From: Green, Victoria - Oxfordshire County Council <Victoria.Green@Oxfordshire.gov.uk>
Sent: 08 December 2023 14:56
To: Planning
Subject: Ref: 23/03231/F

Ref: 23/03231/F Hawthorn Hart Land, Wroxton Lane, Horley, OX15 6BB

REVISION - 0 DRAWING NO - MT / 1564 / 1

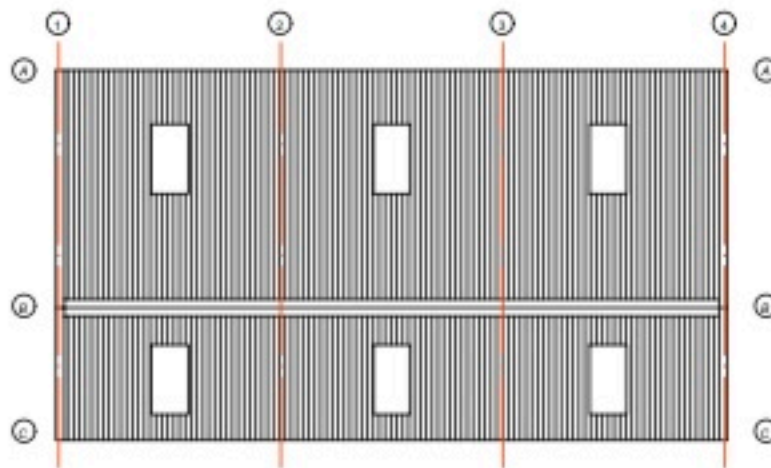
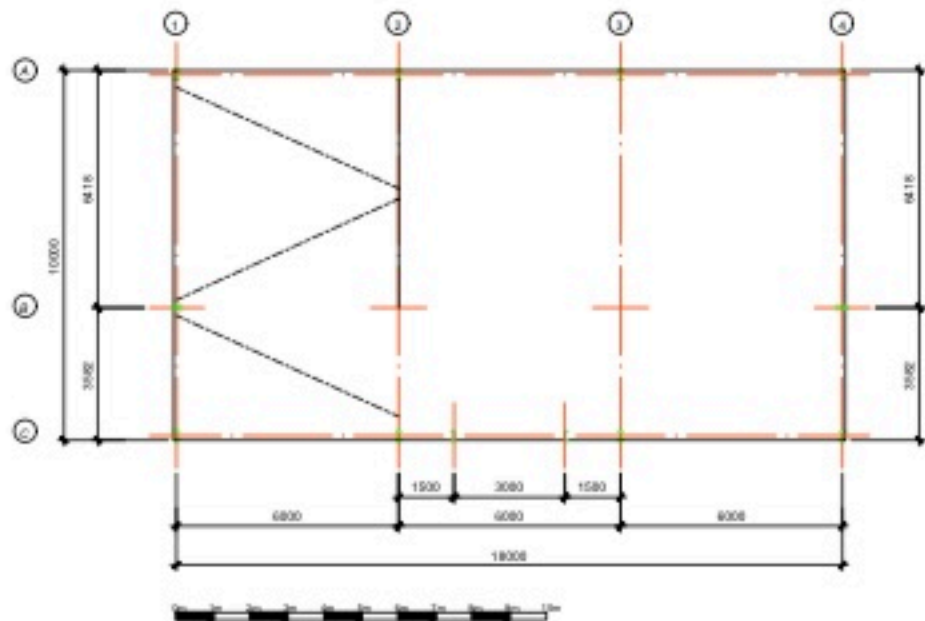
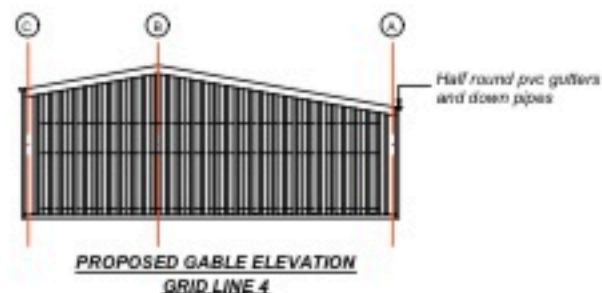
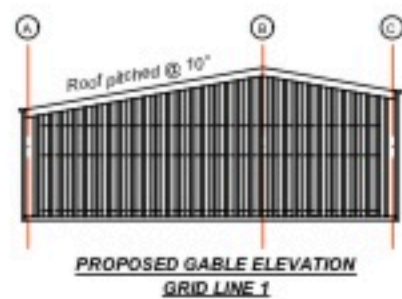
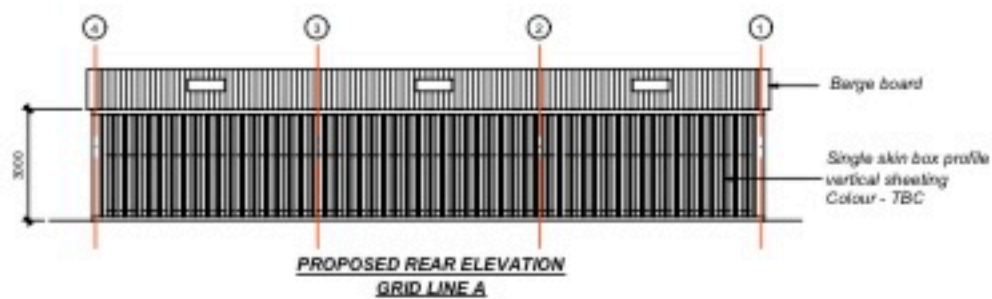
Thank you for consulting us on this application. The site lies in an area of archaeological interest and potential, immediately south of the remains of the shrunken Medieval Village of Horley (PRN 13932). These remains are clearly visible on the Environment Agency LiDAR survey of the area, and potentially continue across the water course into the development site. We would recommend that the proposed location of the agricultural building is moved to the southern boundary of the land parcel to avoid any potential remains relating to the medieval village. If the location cannot be changed, then we would advise an archaeological watching brief is carried out.

We would recommend that, should planning permission be granted with the building in its current proposed location, the applicant should be responsible for ensuring the implementation of an archaeological monitoring and recording action (watching brief) to be maintained during the period of construction. This can be ensured through the attachment of a suitable negative condition along the lines of:

1. The applicant, or their agents or successors in title, shall be responsible for organising and implementing an archaeological watching brief, to be maintained during the period of construction/during any groundworks taking place on the site. The watching brief shall be carried out by a professional archaeological organisation in accordance with a Written Scheme of Investigation that has first been approved in writing by the Local Planning Authority.

2. Following the approval of the Written Scheme of Investigation referred to in condition 1, no development shall commence on site without the appointed archaeologist being present. Once the watching brief has been completed its findings shall be reported to the Local Planning Authority, as agreed in the Written Scheme of Investigation, including all processing, research and analysis necessary to produce an accessible and useable archive and a full report for publication which shall be submitted to the Local Planning Authority within two years of the completion of the archaeological fieldwork.
